**West Nowra Resource Recovery Park Stage 2 (SSD-9887)
Response to submissions**

Appendix 1: Additional Information Request West Nowra Resource Recovery Facility Stage 2 (SSD-9887)

Figure 01

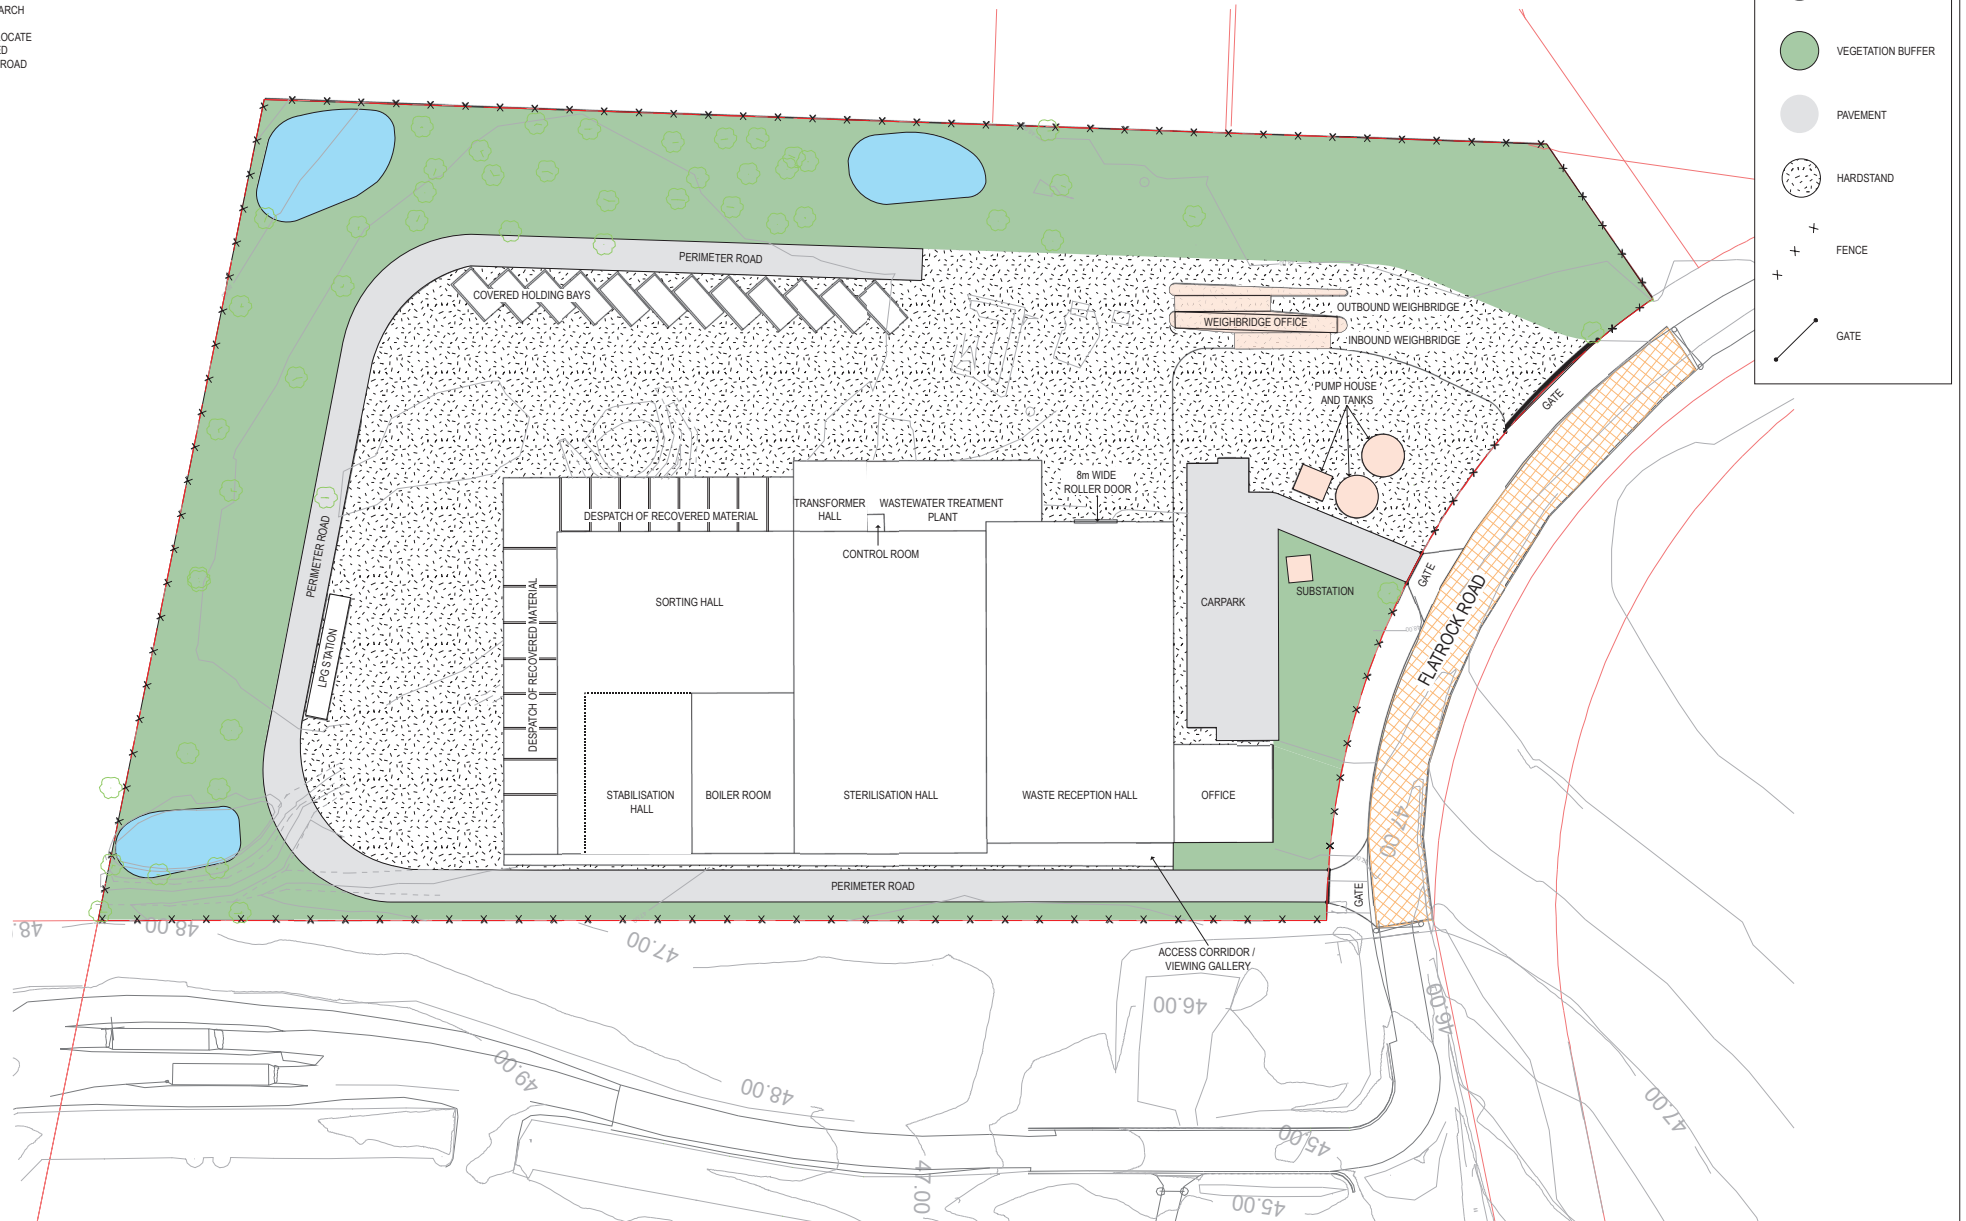
- Provide the construction material types for the external surfaces (e.g. what is the “hardstand” area proposed to be constructed of (road building gravel, concrete, asphalt?)

- Provide a plan for the car park showing traffic flow and parking spaces in accordance with Australian Standard 2890.
 - Provide the location of the proposed 1MW solar system.

- A Site Analysis Plan detailing the location of adjoining buildings, structures and uses is required.
 - Provide location of essential services (potable water and electricity)

Figure 02

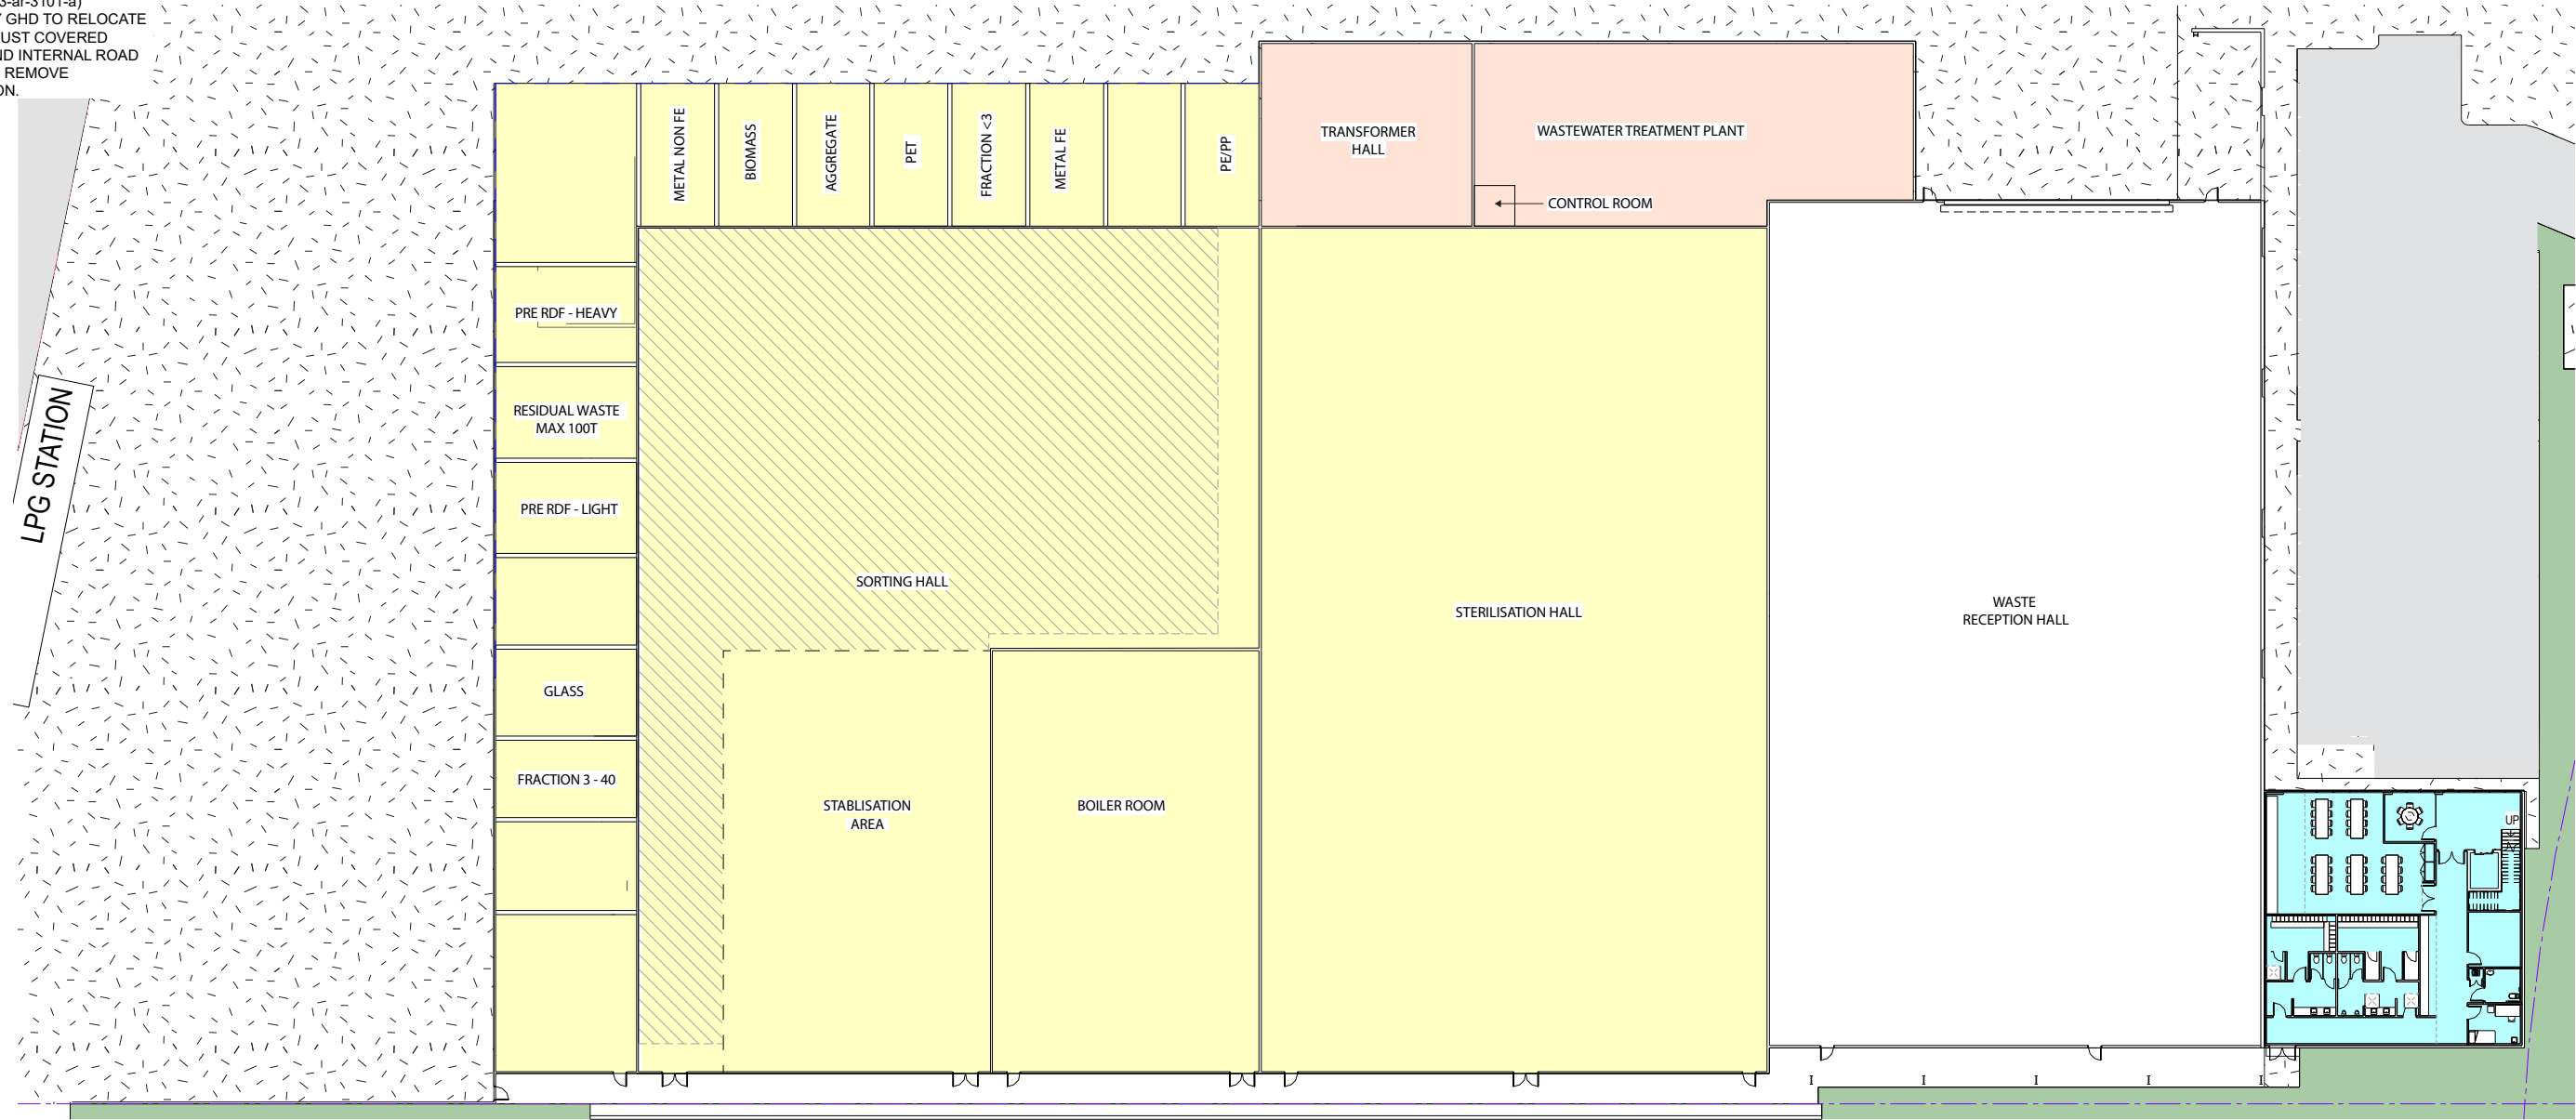
- Floor Plans
 - The location of all proposed plant and equipment, stockpiles, conveyors is required – similar to image on pg. 40.
 - Provide the location of waste inspection area inside the reception hall.

- Provide the location of non-conforming waste stockpiles or areas.
 - Details of any internal leachate management system (pit and pipe network, blind sumps, grates?).

- Details of any bunded areas proposed.
 - Provide the maximum stockpiling capacity of each recovered material bay.
 - Provide the location of the two unloading areas for the incoming waste including push walls.

- Location of the ventilation and process air extraction system.
 - A concept Landscaping Plan is required to be submitted as an Appendix to the EIS and discussed and assessed throughout the EIS where necessary.

Figure 4-1 Site water balance structure during facility operation

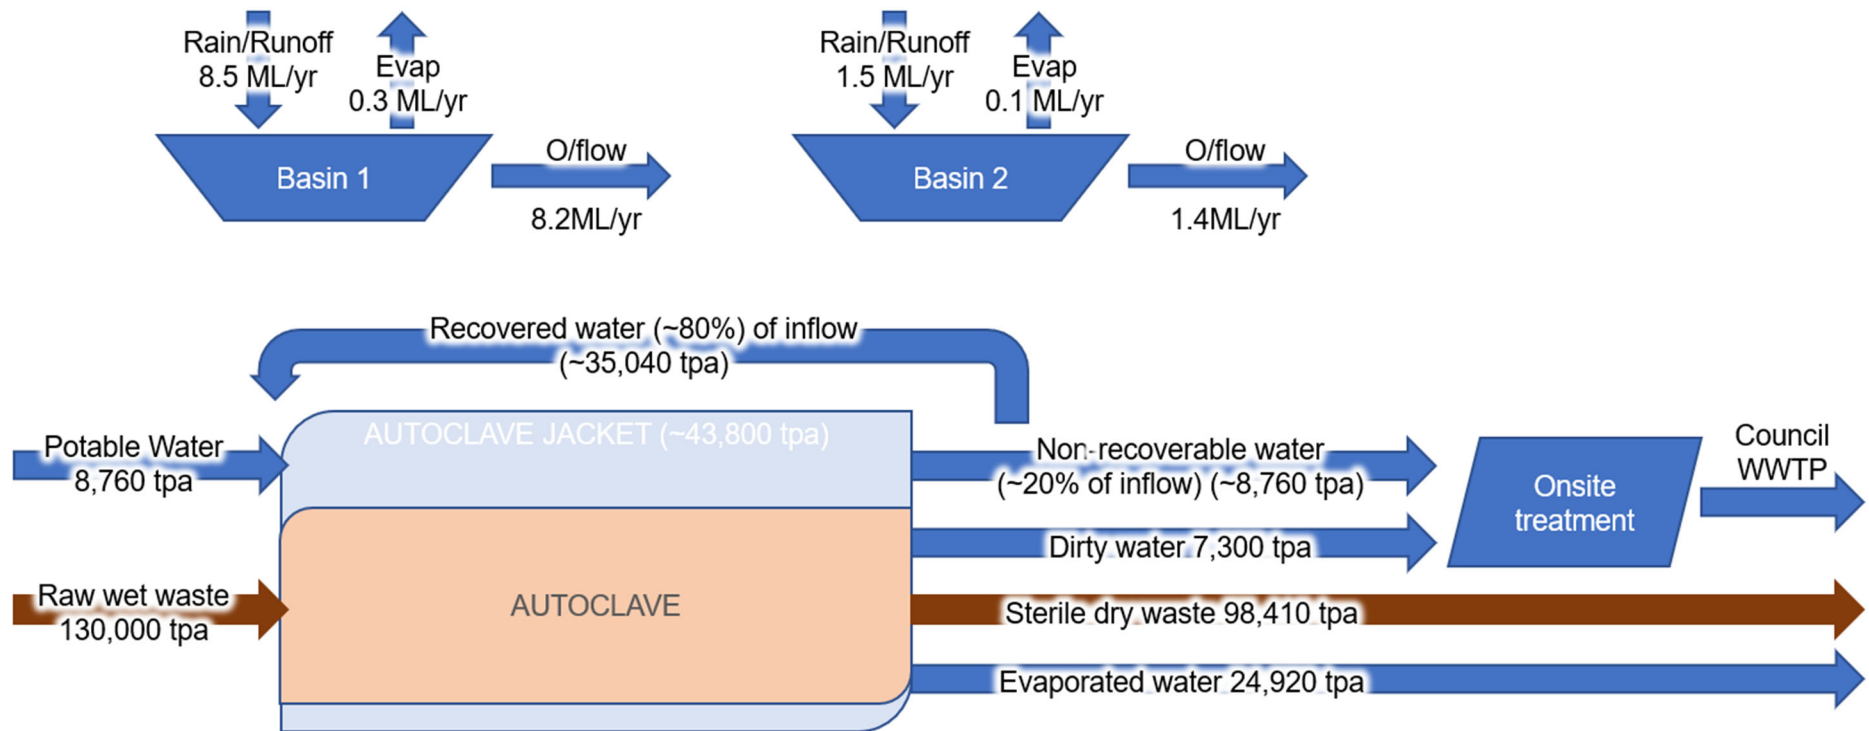
- Location of wastewater tanks discussed in section 3.1.1 of the Soil and Water Assessment.
 - It is unclear how stormwater from hardstand areas would be directed to the proposed pipe/culvert network.
